G-5713

Subject: Addendum to Geotechnical Engineering Report, New Residence,
3064 – 68th Avenue SE, Mercer Island, Washington.

Reference: Geotechnical Engineering Investigation, New Residence, 3064 – 68th Avenue SE,
Mercer Island, Washington. GEO Group Northwest, Inc., May 9, 2022.

Sheet Information	
Job Number	2209
Drawn	DR / TL
Checked	SB
Title	BUILDING SECTIONS

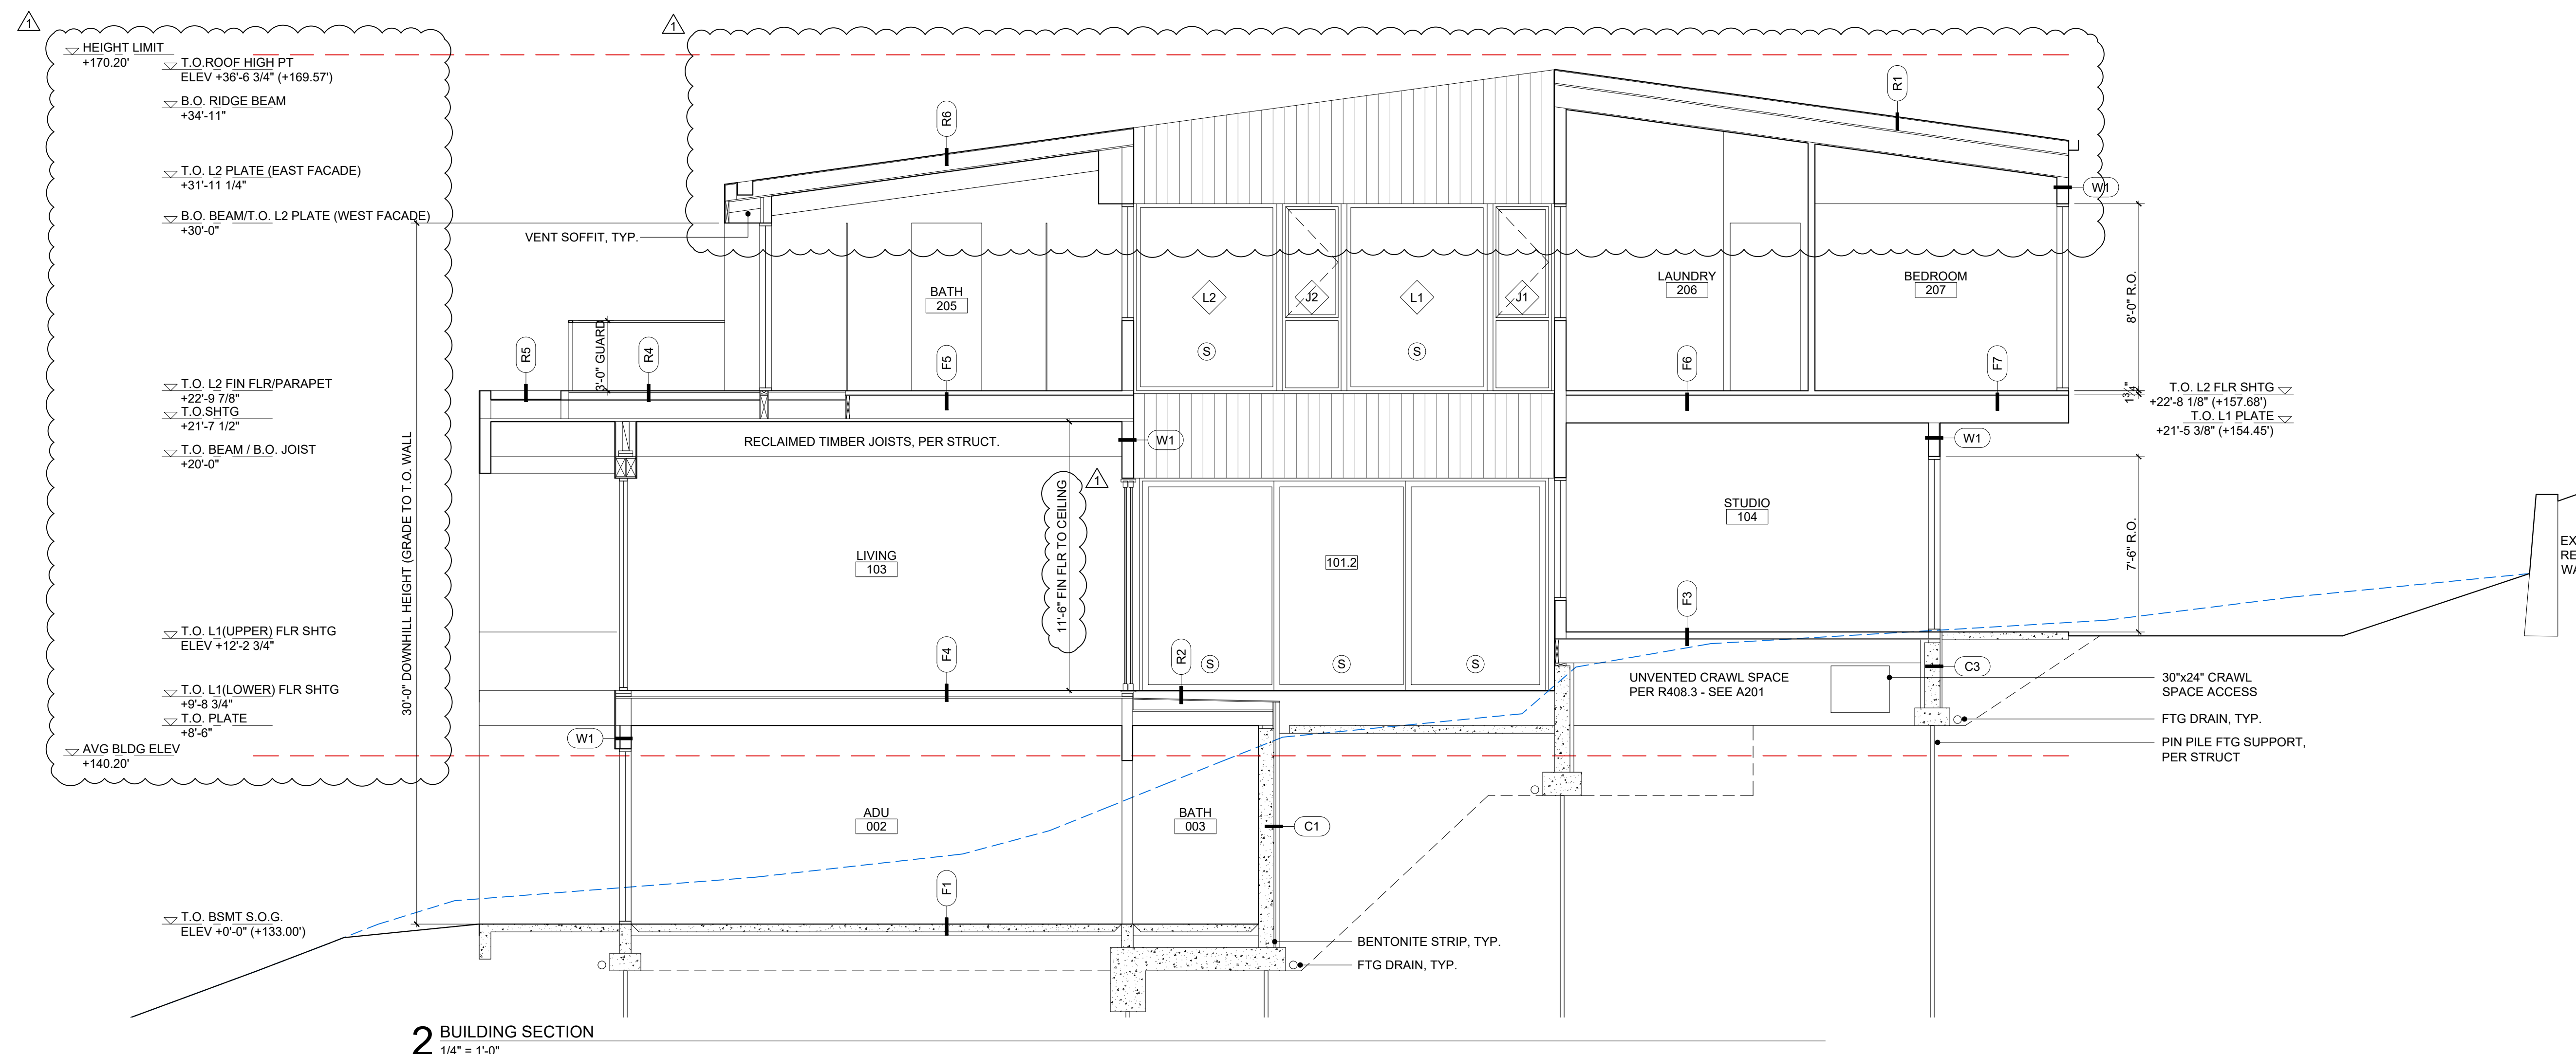
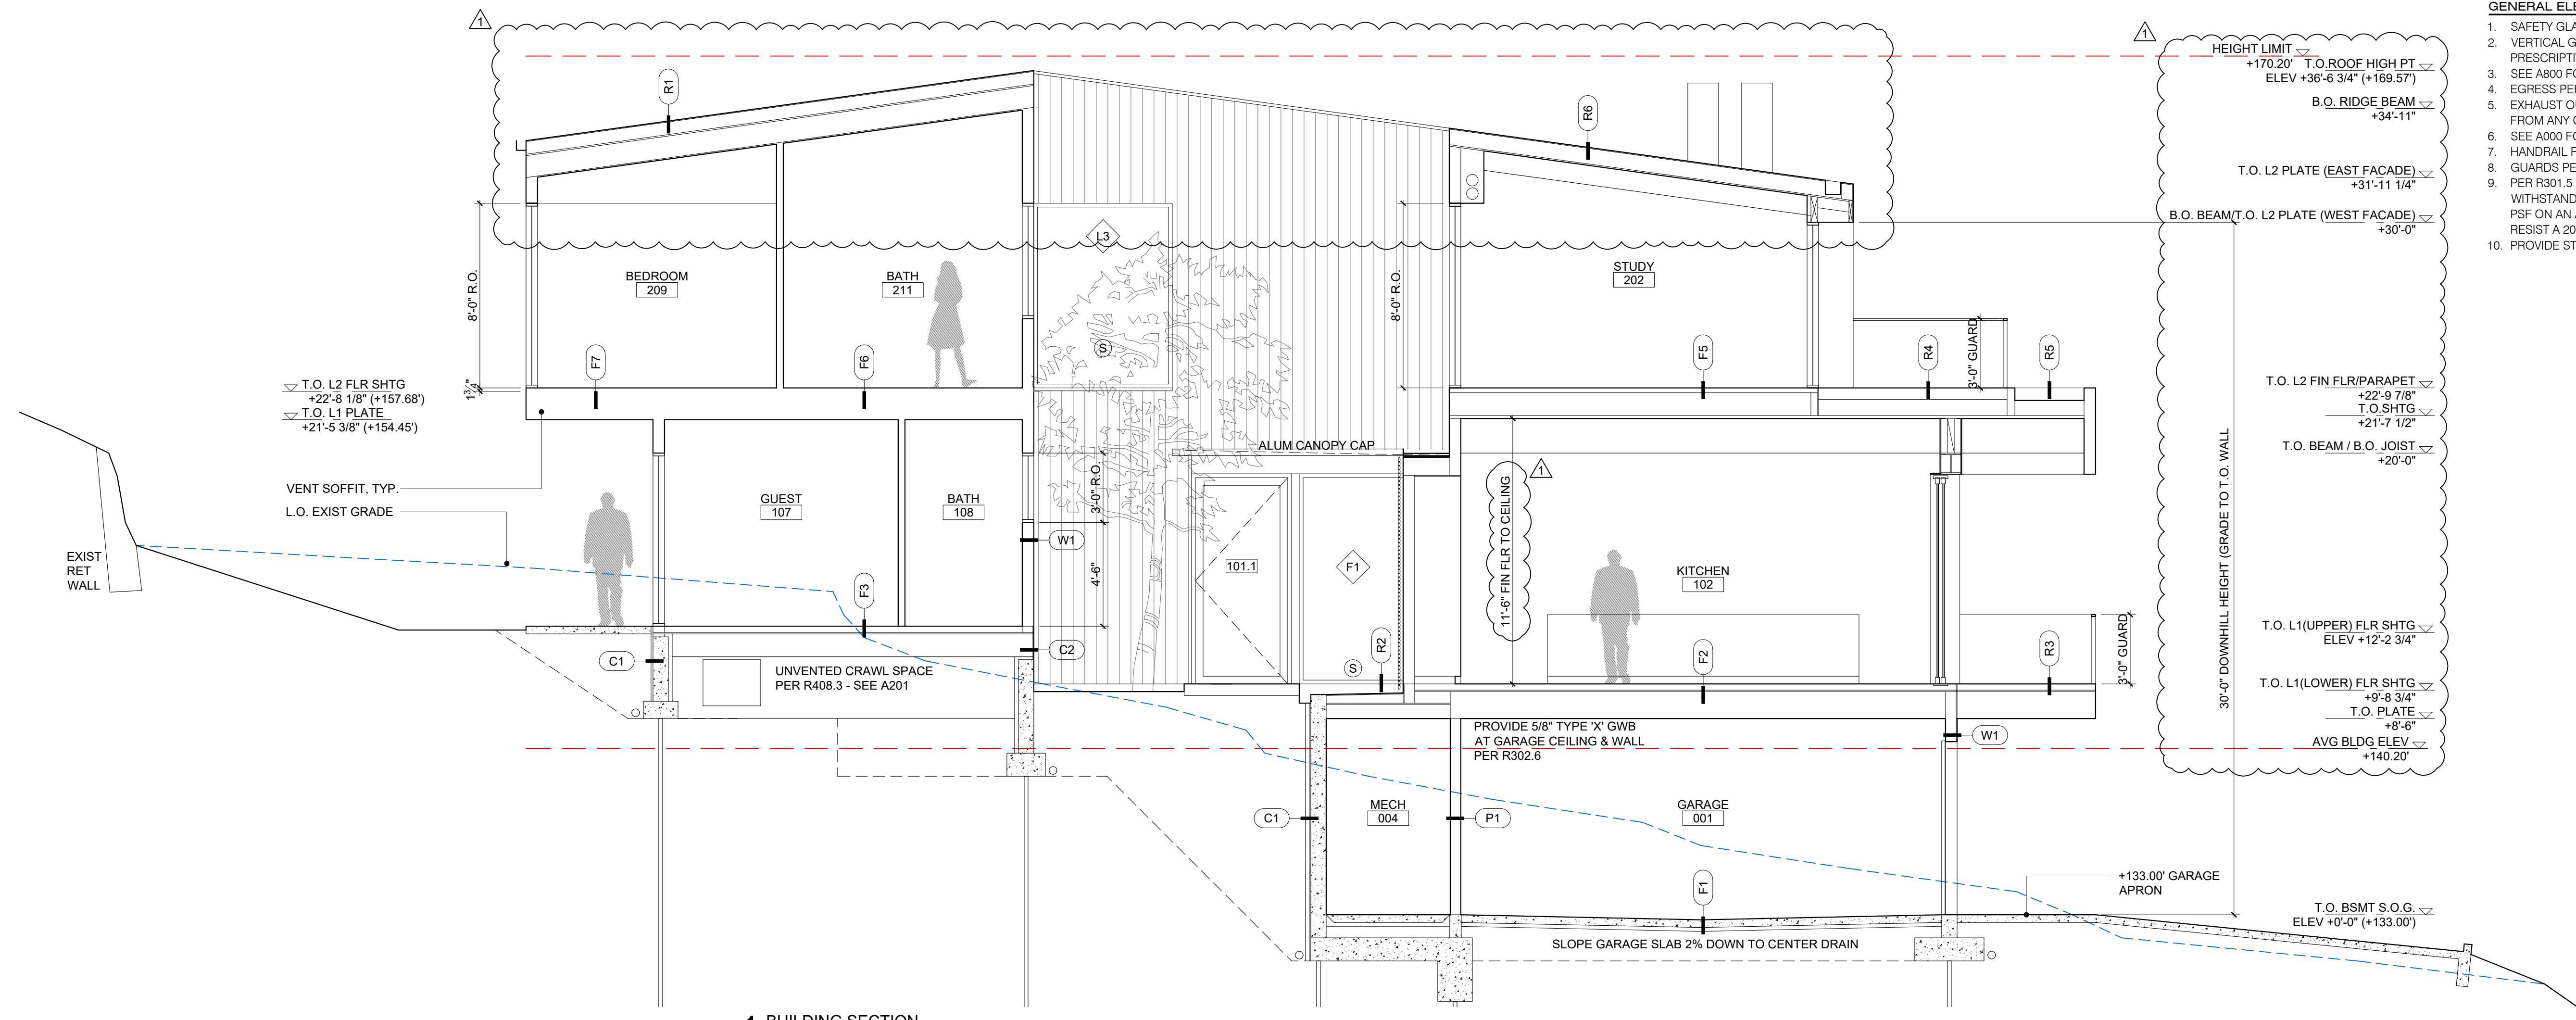
Please provide slope stability analyses of maximum proposed temporary open cuts, e.g., as required to construct sections 1/A301, 2/A301 and 1/A401. Provide alternate means to support the excavation if slope stability analyses indicate marginally stable or unstable open cut conditions.

This temporary cut slope angle is steeper than recommended by the geotechnical engineer (p.9 of report). Geotechnical engineer to provide slope stability analyses of proposed open cut to verify that adequate FS exists. Alternatively, provide temporary shoring recommendations.

Geotechnical engineer to review proposed temporary open cut and provide assessment as to whether this cut can be made as shown given anticipated subsurface conditions. Alternatively provide temporary shoring recommendations in a report addendum that does not encroach on the adjacent property.

Following our review of the Cycle 1 Correction Set of the proposed project plans and our completion of additional slope stability analysis for the project, we have developed the following revisions to the temporary excavation recommendations contained in our geotechnical report:

- Temporary excavations greater than 4 feet in depth should be sloped no steeper than 1.25H:1V, except where dense soils are present. In dense soils, these excavations can be sloped to 1H:1V.
- Following consideration of our supplemental slope stability analysis results, it is our opinion that our previous recommendation regarding temporary excavations in the eastern part of the site (on page 9 of our report) can be revised from 1.5H:1V to 1.25H:1V.

We understand that a portion of the northeast corner of the temporary excavation for constructing the new residence will need to be supported because of the lack of available space on the property for an open cut consistent with our recommendations. The height of the supported portion of the cut is planned to be 5 feet, and the length of the supported cut is planned to be approximately 10 feet. For this situation, temporary support can be provided by using modular concrete blocks such as Ultrablocks or similar product. A section profile for the proposed cut with shoring is presented in Plate 2 – Temporary Block Wall Shoring Detail.

TYPICAL PIPE PILE EMBEDMENT
1-1/2" = 1'-0" 3

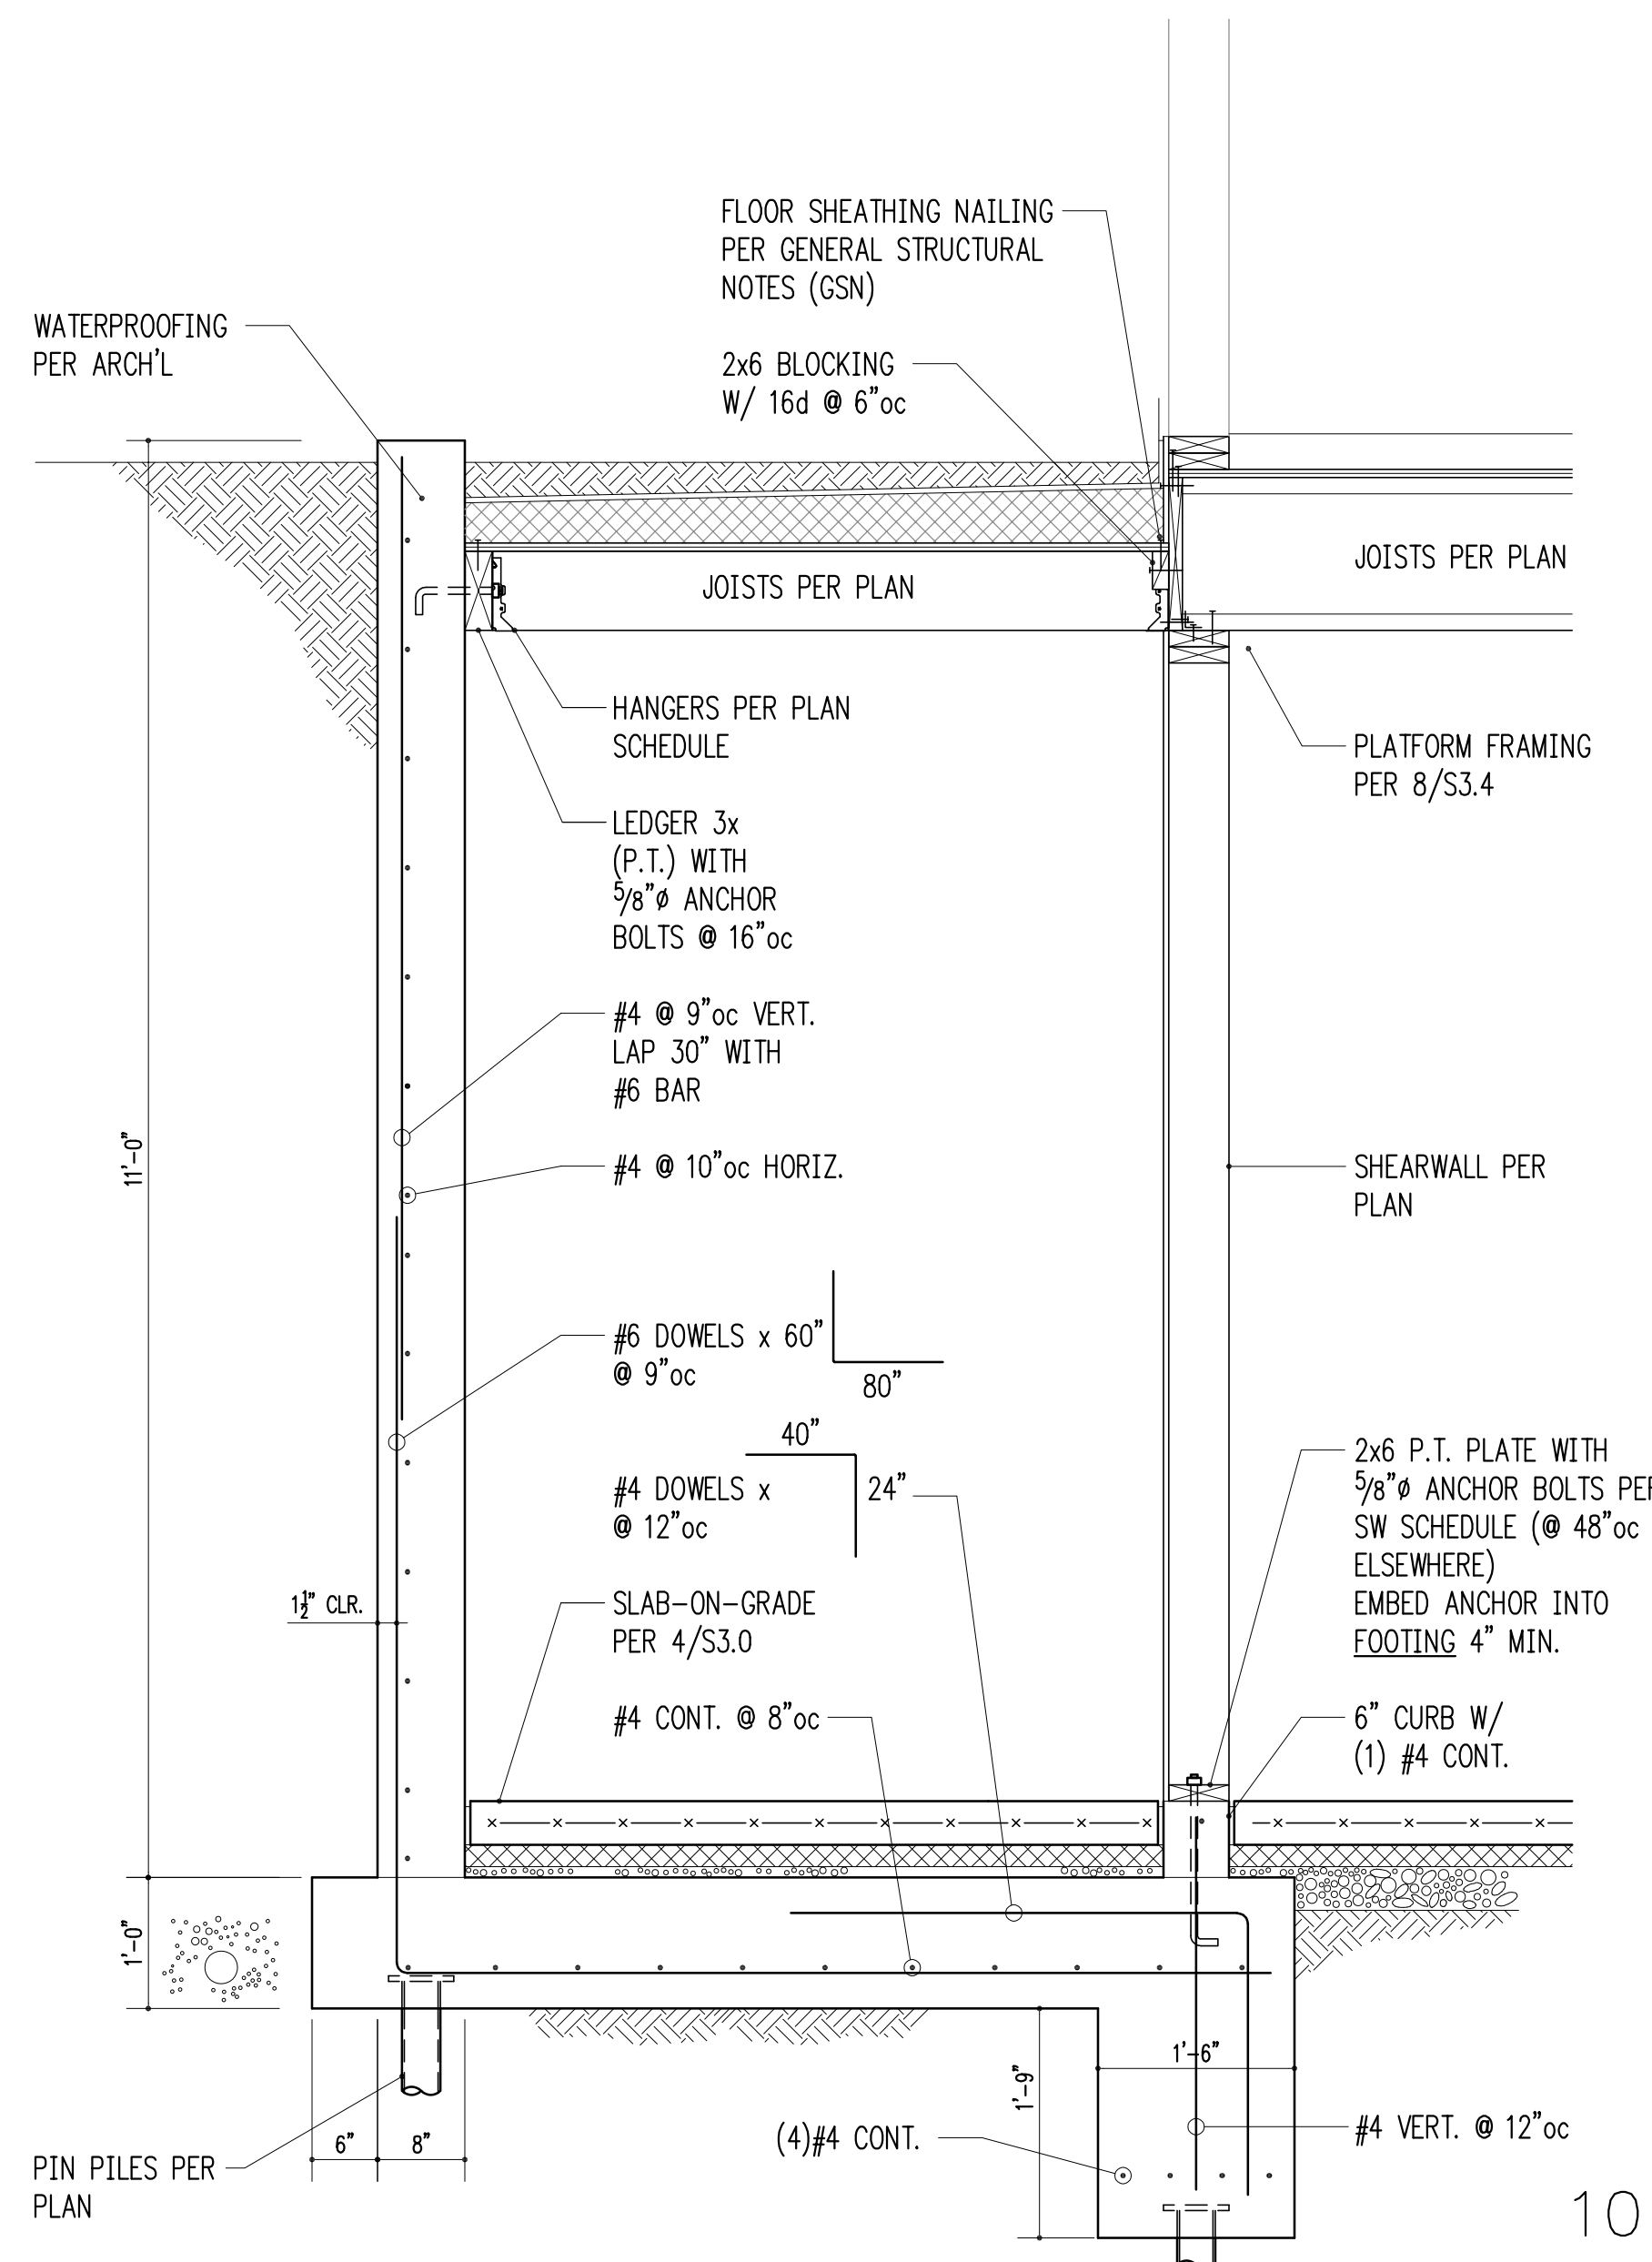
Number: 1 Author: Geotechnical Peer Review (michele.lorilla@mercergov.org) Subject: Comment Date: 4/17/2023 7:12:03 AM
If larger diameter pin piles are used due to potential lengths exceeding 30 feet for 2-inch diameter pin piles, please include pin pile load testing requirements.

ASTM quick test (D1143) required on minimum 3% of piles up to 5 piles maximum (1 minimum).

The project has been revised to use 3”-diameter pipe piles instead of 2”-diameter to accommodate the potential that some pile lengths may exceed 30 feet. Load testing of at least 3 percent of the piles (up to a maximum of 5 piles tested) should be performed during the project per the quick-load test method described in ASTM D1143.
